Re: Estates at Rolling Hills Ranch No. 2

This firm represents the Upper Black Squirrel Creek Ground Water Management District (“the District”). Applicant, GTL Development, Inc., provided materials in support of its application for a PUD Development Plan/Preliminary Plan and Final Plat for its proposed Estates at Rolling Hills Ranch No. 2 subdivision development (“Proposed Development”). The Proposed Development is located within the District and, as explained in the Applicant’s application, will consist of 98 lots on 117 acres within the Meridian Ranch Subdivision. The District reviewed the Applicant’s application materials and submits the following comments:

OVEREXCAVATION DRAIN DETAIL

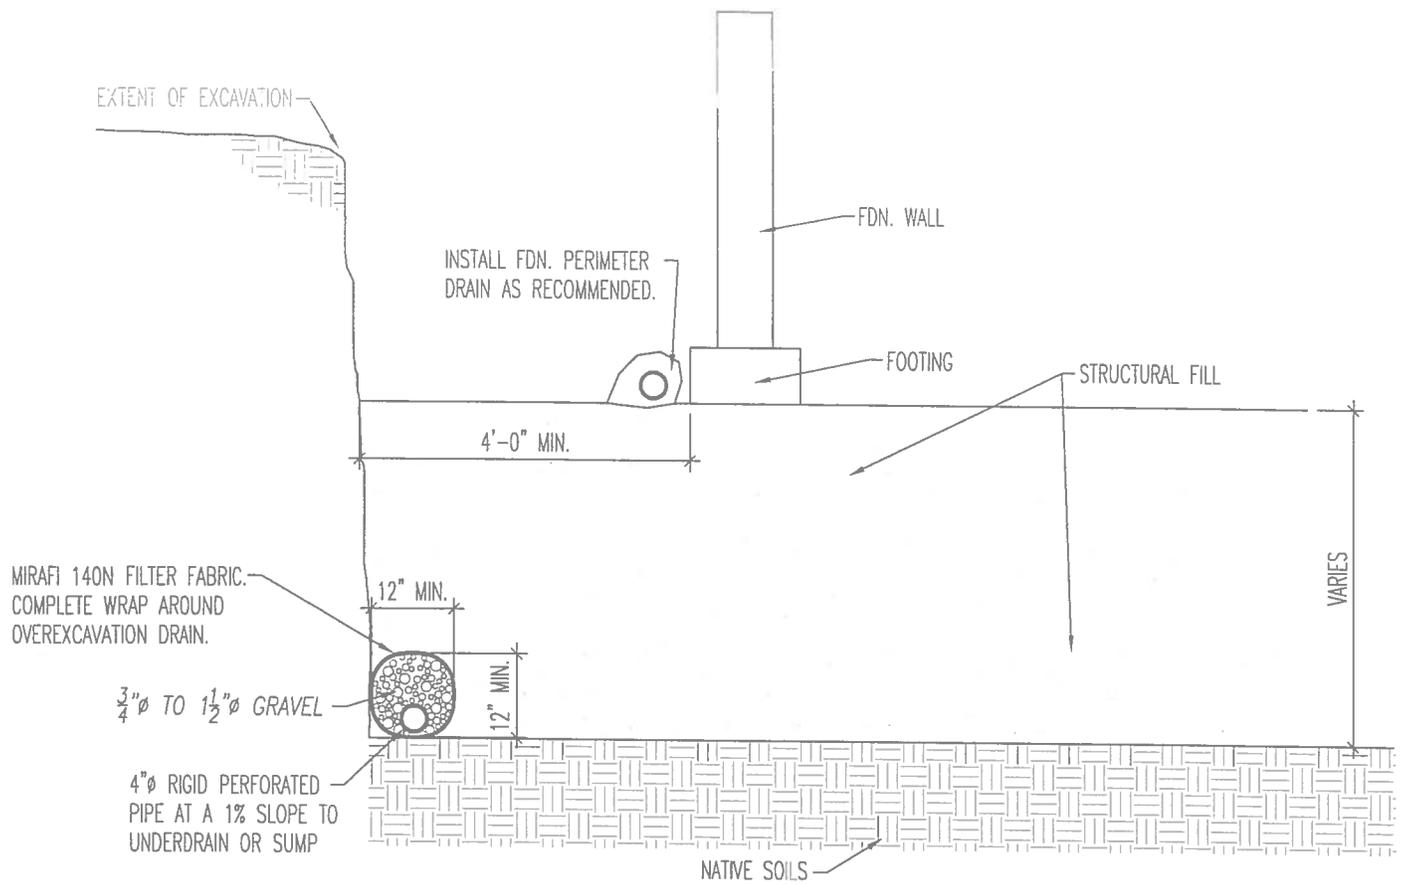
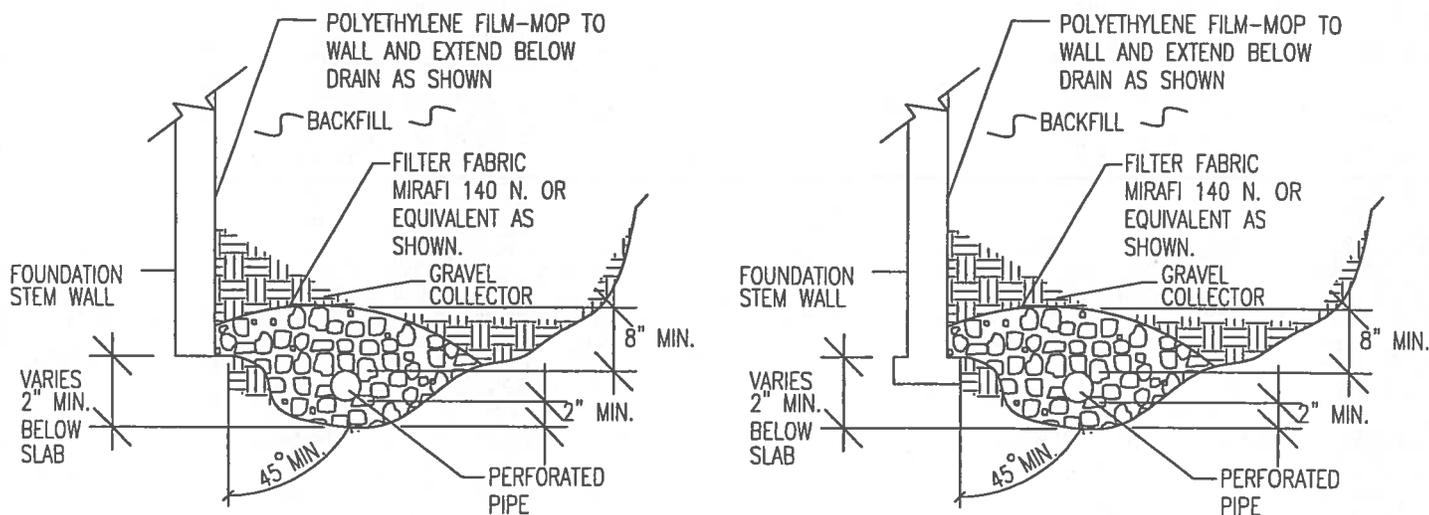
Due to local high ground water and soil conditions in the area of the Proposed Subdivision, structures developed in the Proposed Subdivision may need underdrains to capture and drain water that would otherwise flood those structures. Any underdrains will require a large capacity well permit and those well permits will require a replacement plan in compliance with Designated Basin Rule 5.6. Any such replacement plan should meet the requirements of Designated Basin Rule 5.6 by replacing any groundwater collected in any of the underdrains that is discharged to the surface and for the evaporation and ET associated with the exposure of groundwater caused by the underdrain. Applicant's application includes no information on whether underdrains will be required and, if so, how Applicant intends to meet the requirements of Designated Basin Rule 5.6.
